From: [Holly Erdman](#)
To: [Rachael Stevie \(CD\)](#)
Cc: [Jesse Cox](#)
Subject: RE: BL-20-00008 Ogg - Notice of Application
Date: Wednesday, March 18, 2020 9:49:30 AM
Attachments: [image001.png](#)

From: Rachael Stevie (CD) <rachael.stevie.cd@co.kittitas.wa.us>
Sent: Wednesday, March 11, 2020 10:30 AM
To: Pat Nicholson <pat.nicholson@co.kittitas.wa.us>; Candie Leader <candie.leader@co.kittitas.wa.us>; Holly Erdman <Holly.erdman@co.kittitas.wa.us>; Jesse Cox <jesse.cox@co.kittitas.wa.us>
Cc: Lindsey Ozbolt <lindsey.ozbolt@co.kittitas.wa.us>
Subject: BL-20-00008 Ogg - Notice of Application

Please review the following Boundary Line Adjustment application submitted David and Kathleen Ogg (BL-20-00008). Any comments need to be submitted by 5pm on March 26, 2020. Please let me know if there are any questions.

BOUNDARY LINE ADJUSTMENT BL-20-00008

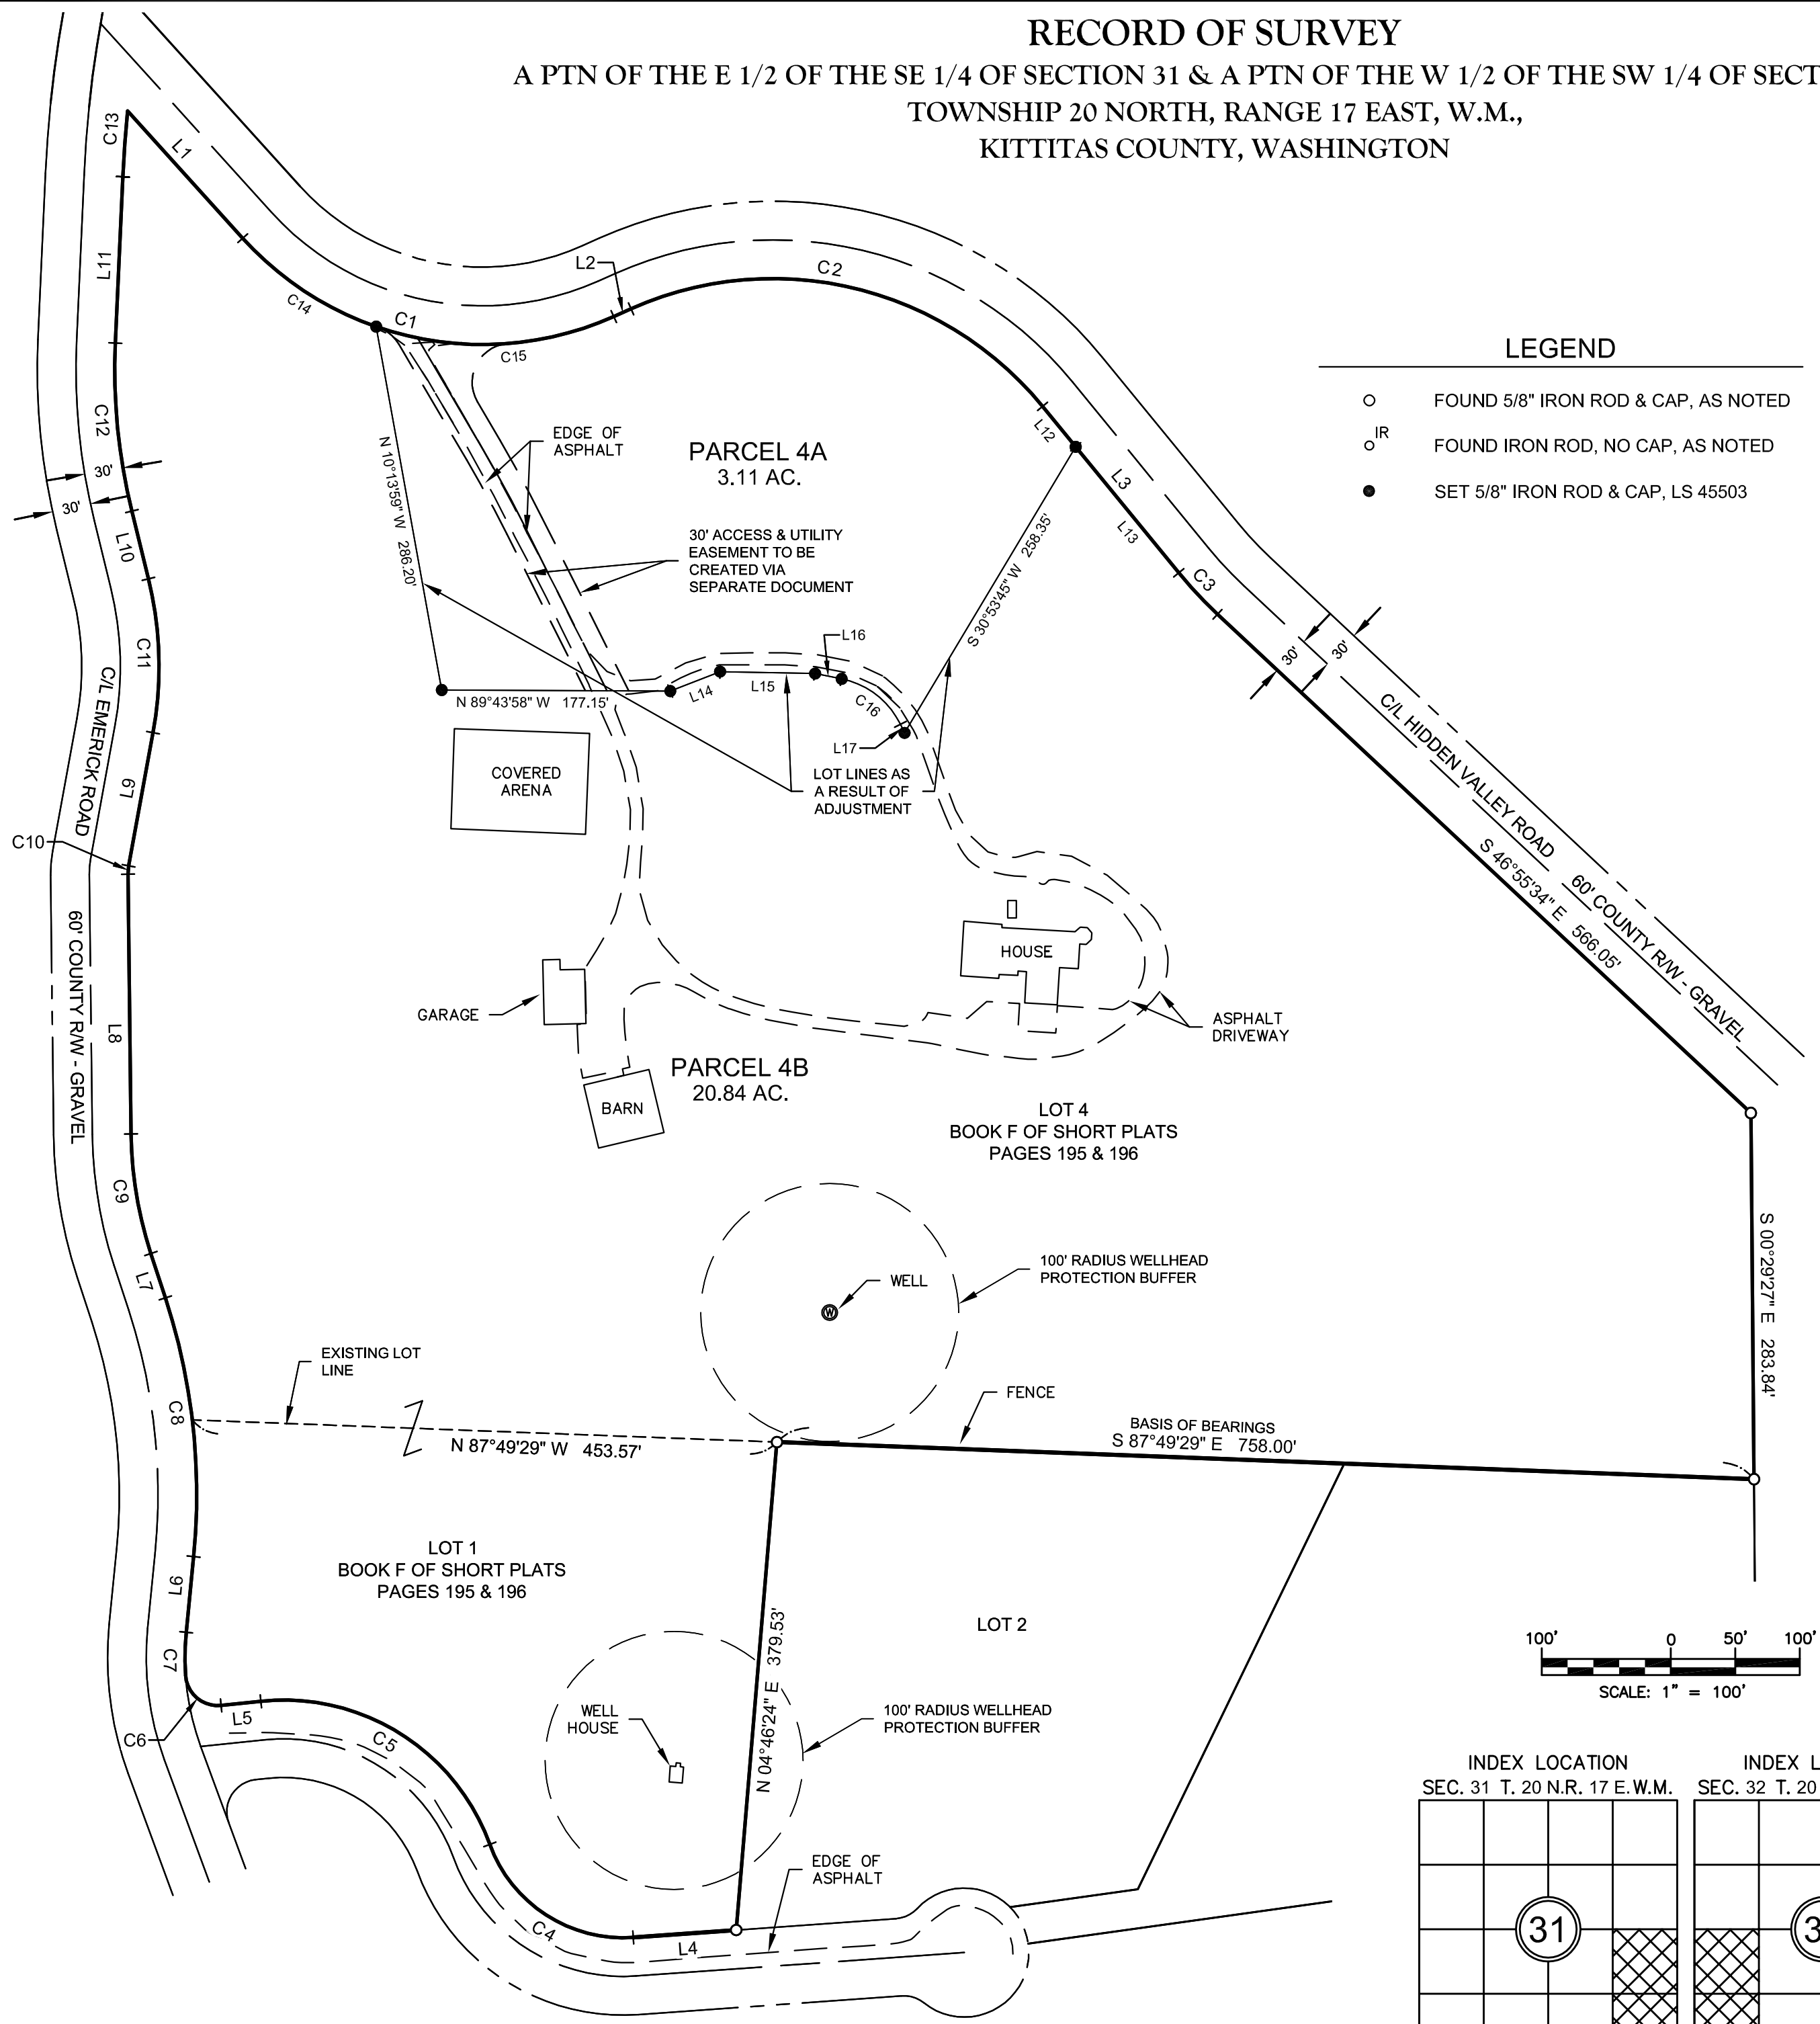
The well located on lot 1 is approved as a Group B well that is to provide potable water to future houses built on lot 2 and lot 3 of the Lang Short Plat. The concern is that once lot 1 of the Lang Short Plat is added (the boundary line between lot 1 and lot 4 is eliminated) to lot 4, that lots 2 and 3 will not have access to the approved Group B well located on lot 1. Prior to approval of the BL-20-00008 a water user's agreement needs to be in place for lots 2 and 3 to continue to have the right to the water. Lots 2 and 3 are currently owned by Al Lang, according to tax sifter.
